Rezoning Transportation Analysis

Petition Number: Zoning Petition #2021-011

General Location Identifier: Tax ID 10304127

Date	Description
02-25-21	First Review (WB)
03-25-21	Second Review (WB)

ENGINEER: GTW
DRAWN BY: GTW
CHECKED BY: JB
PROJECT #: 019-011
SHEET
RZ-1
SHEET 1 OF 2

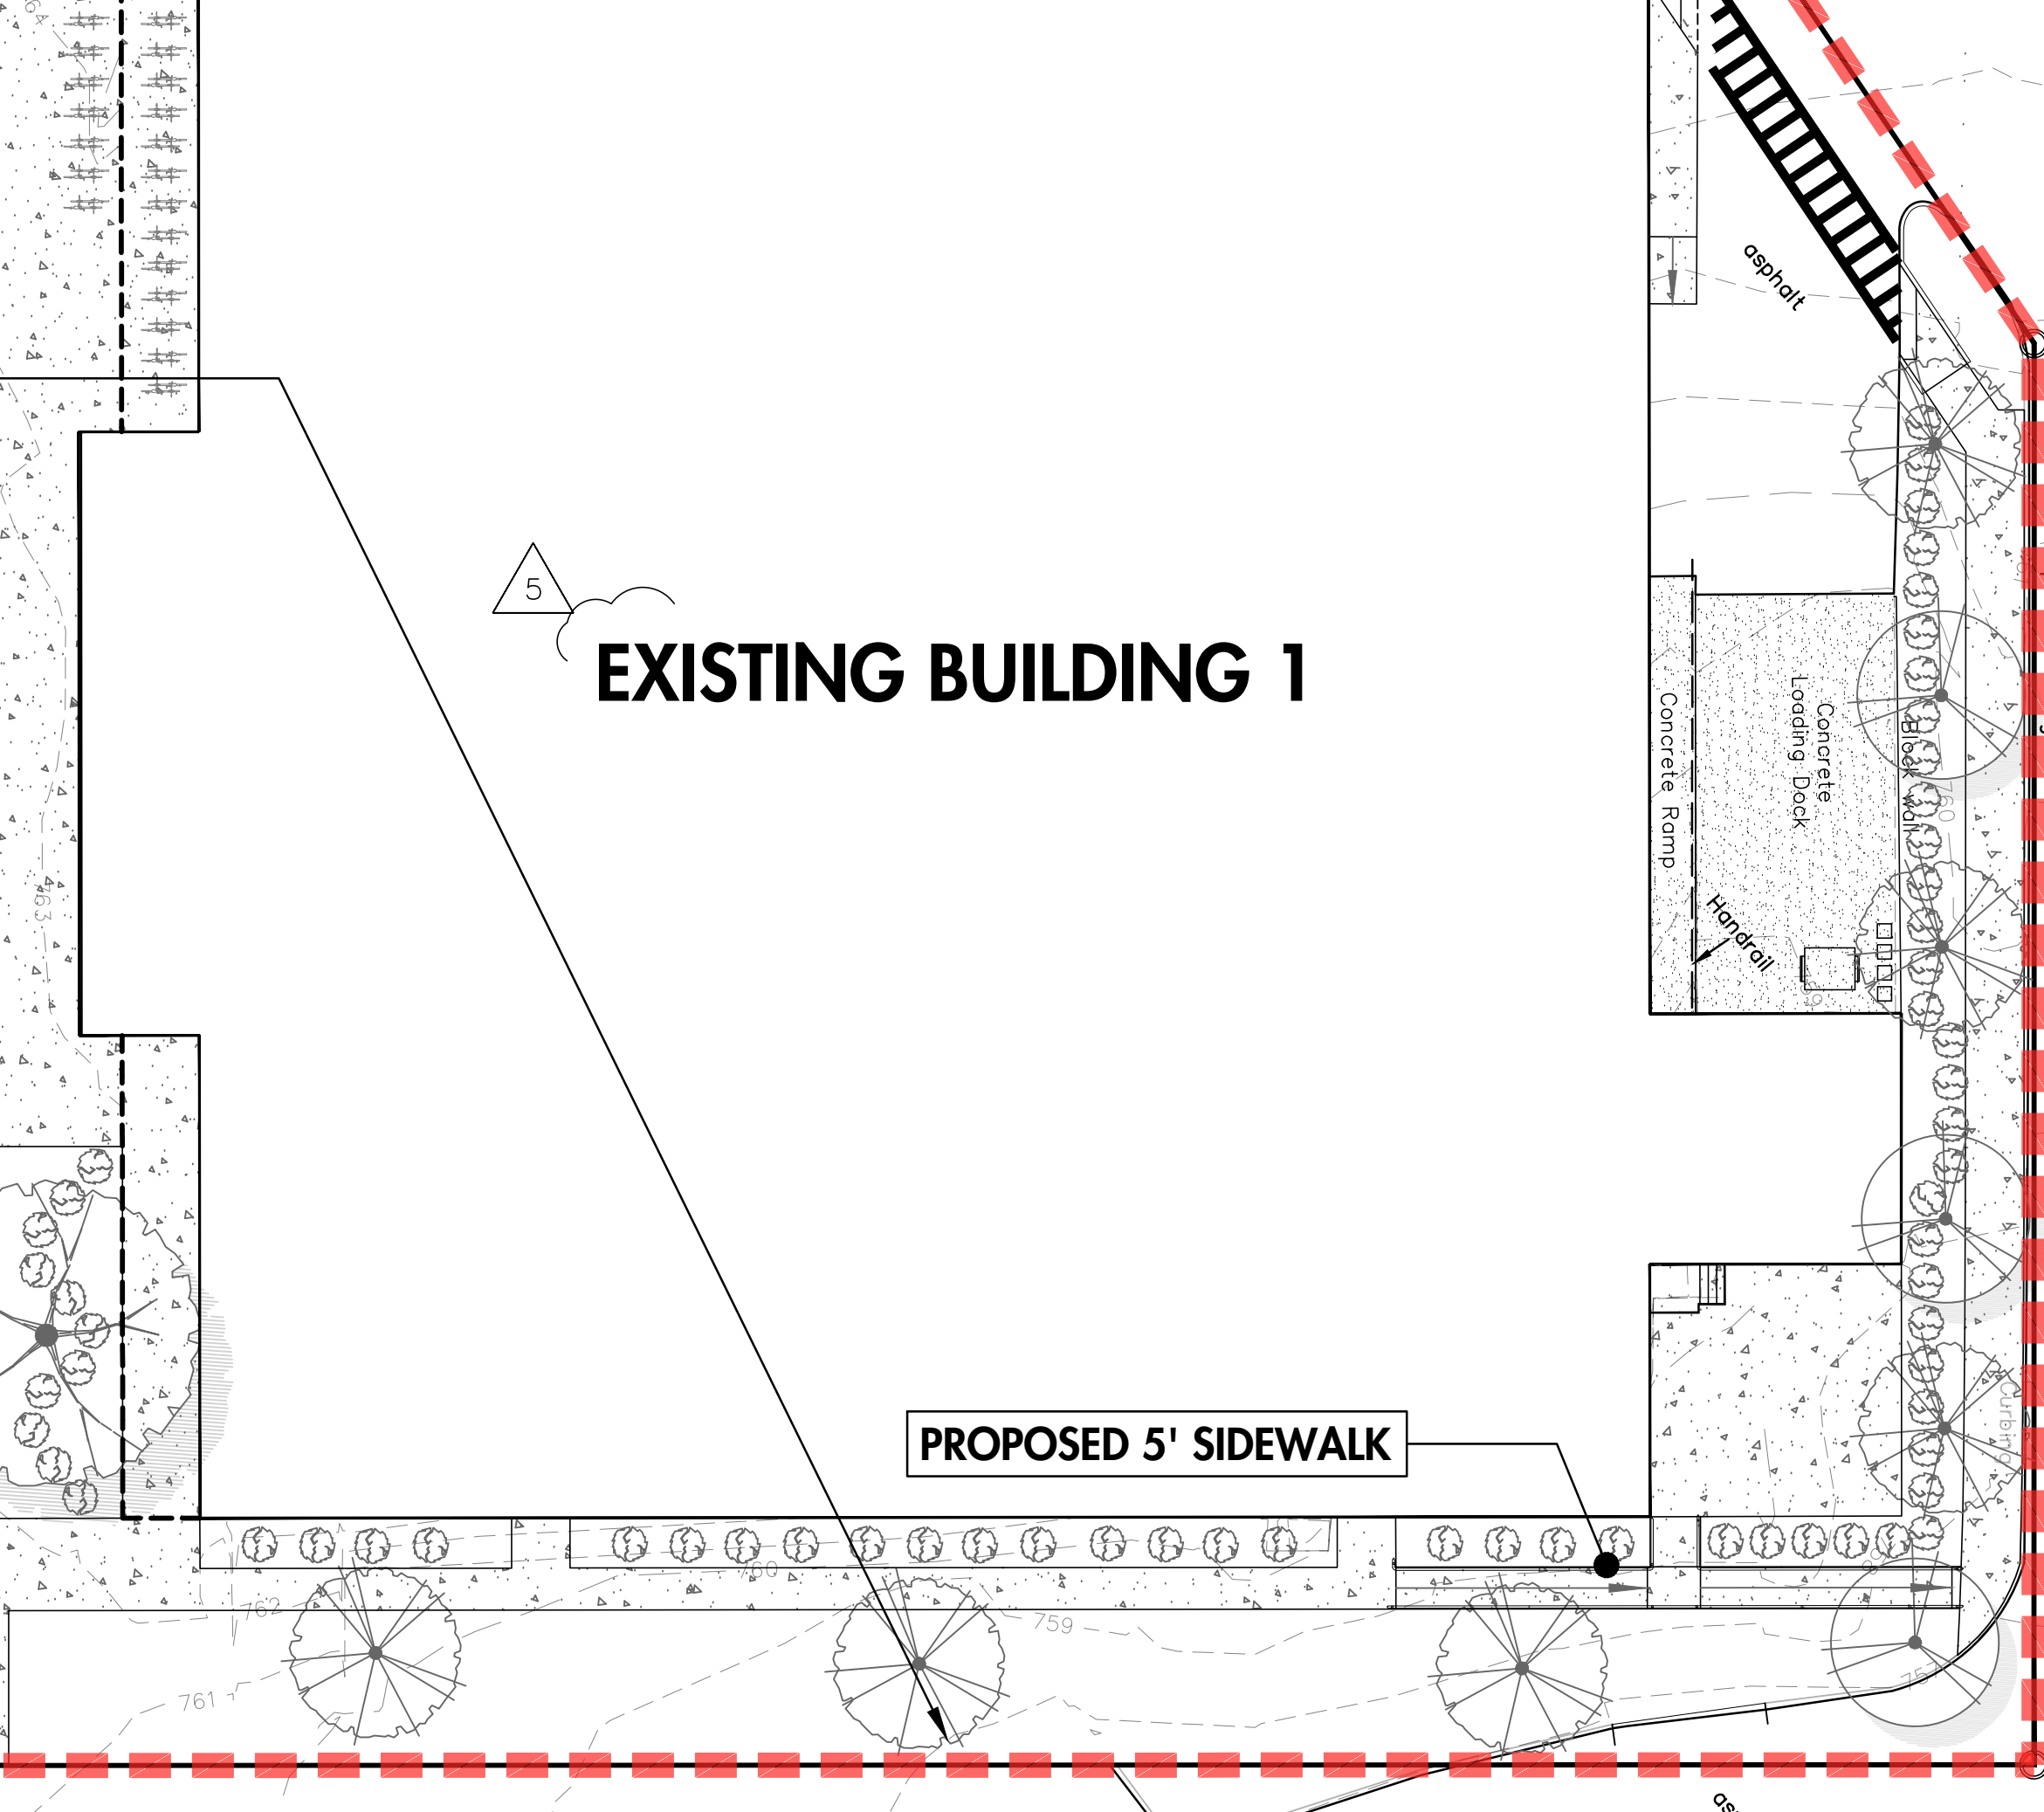
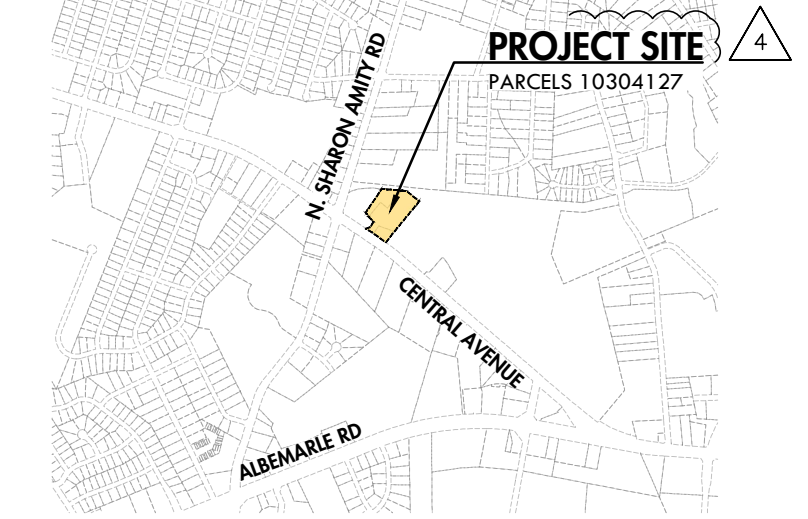
~~**Central Avenue:** Location of curb and gutter needs to be at 38 feet from the centerline to allow for a 4+ Avenue with an 8-foot buffered bike lane. Rescinded (3/22/2021) based on meeting held on March 15th. The future curb and gutter will be located 38 feet from the centerline; however, CDOT will not require the relocation of the existing curb and gutter for this site plan, in order to tie into the CATS Street Car project and maintain a continuous typical section along Central Avenue.~~

~~Label and dimension the existing curb and gutter from the road centerline on the site plan.~~

- ~~6. Add a site plan note specifying dedication and fee simple conveyance of all rights-of-way to the City before the site's first building certificate of occupancy is issued. CDOT requests rights-of-way set at 2' behind back of sidewalk where feasible.~~
